From: Elaine Walby on behalf of Planning.Responses
Sent: 01 April 2026 12:35
To: Planning Scanning
Subject: FW: WSCC Consultation Response from County Highways - Planning Services - LU/25/26/PL

PL- Consultation- WSCC Highways response

1.2 The application is for the change of use and conversion of the building/site to 7 flats. The building has a previous industrial use and residential use, which is a material planning consideration in terms of previous associated vehicle trip and parking related matters.

3238/01/03

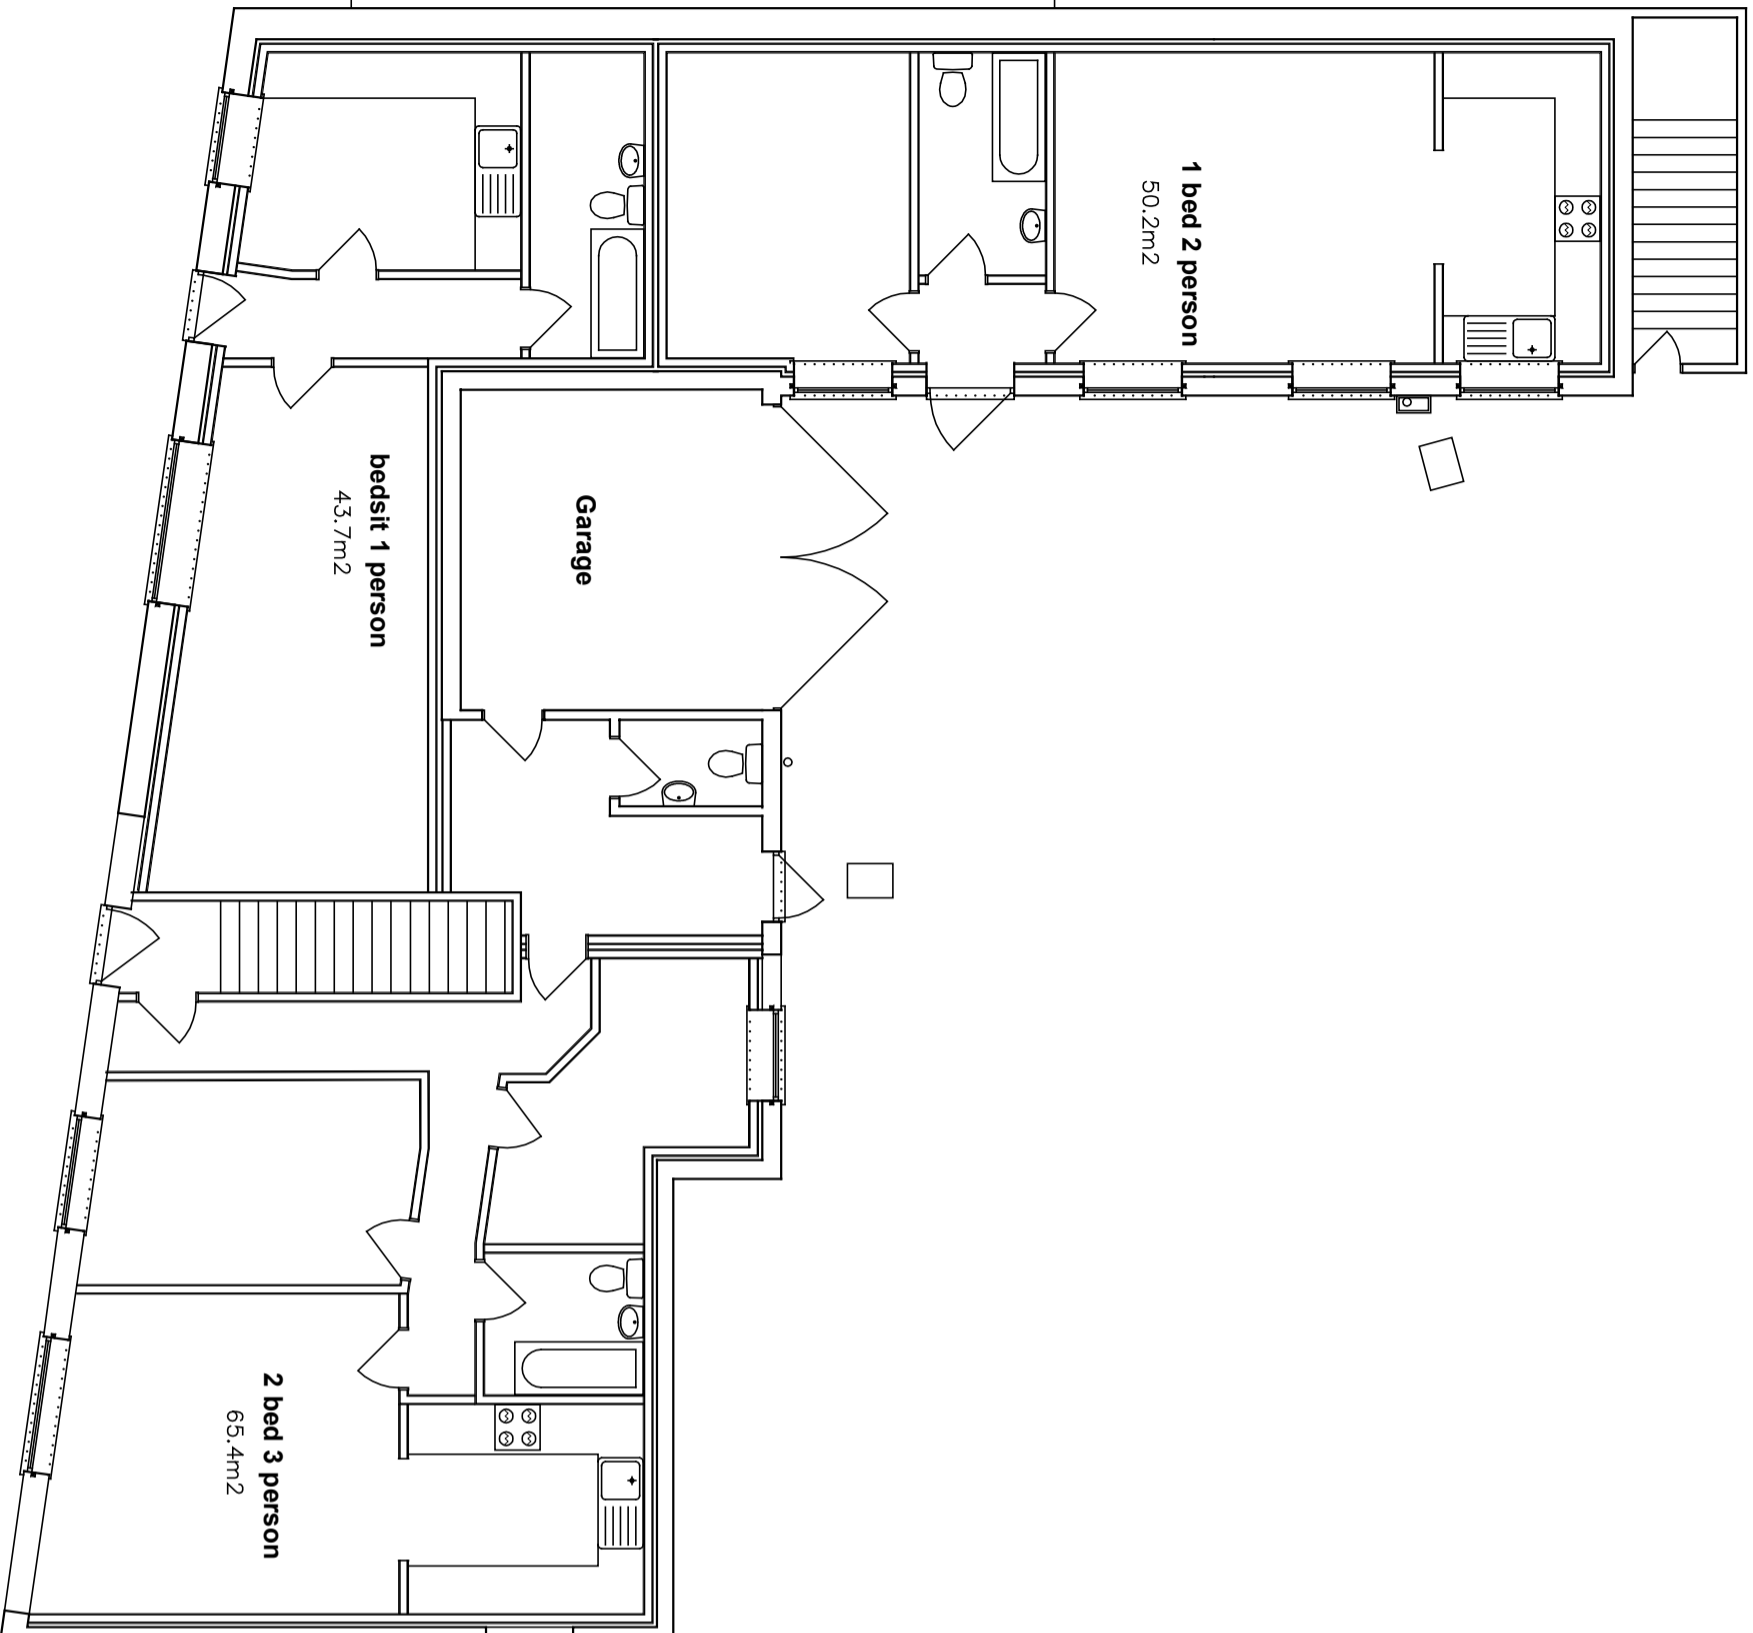
1.3 In terms of highway related matters, it appears that there will be no access from the highway and no parking provided. Whilst a nil parking provision is not ideal the site is in a sustainable location with other means of travel available than that of the private motor vehicle. There is on street parking available which seems well used. There are parking restrictions in place to stop unsafe parking with enforceable measures to prevent a highway safety issue. The LPA may wish to consider on street parking from an amenity perspective.

- Cycle parking No part of the development shall be first occupied until covered and secure cycle parking spaces have been provided in accordance with plans and details to be submitted to and approved by the Local Planning Authority. Reason: To provide alternative travel options to the use of the car in accordance with current sustainable transport policies.
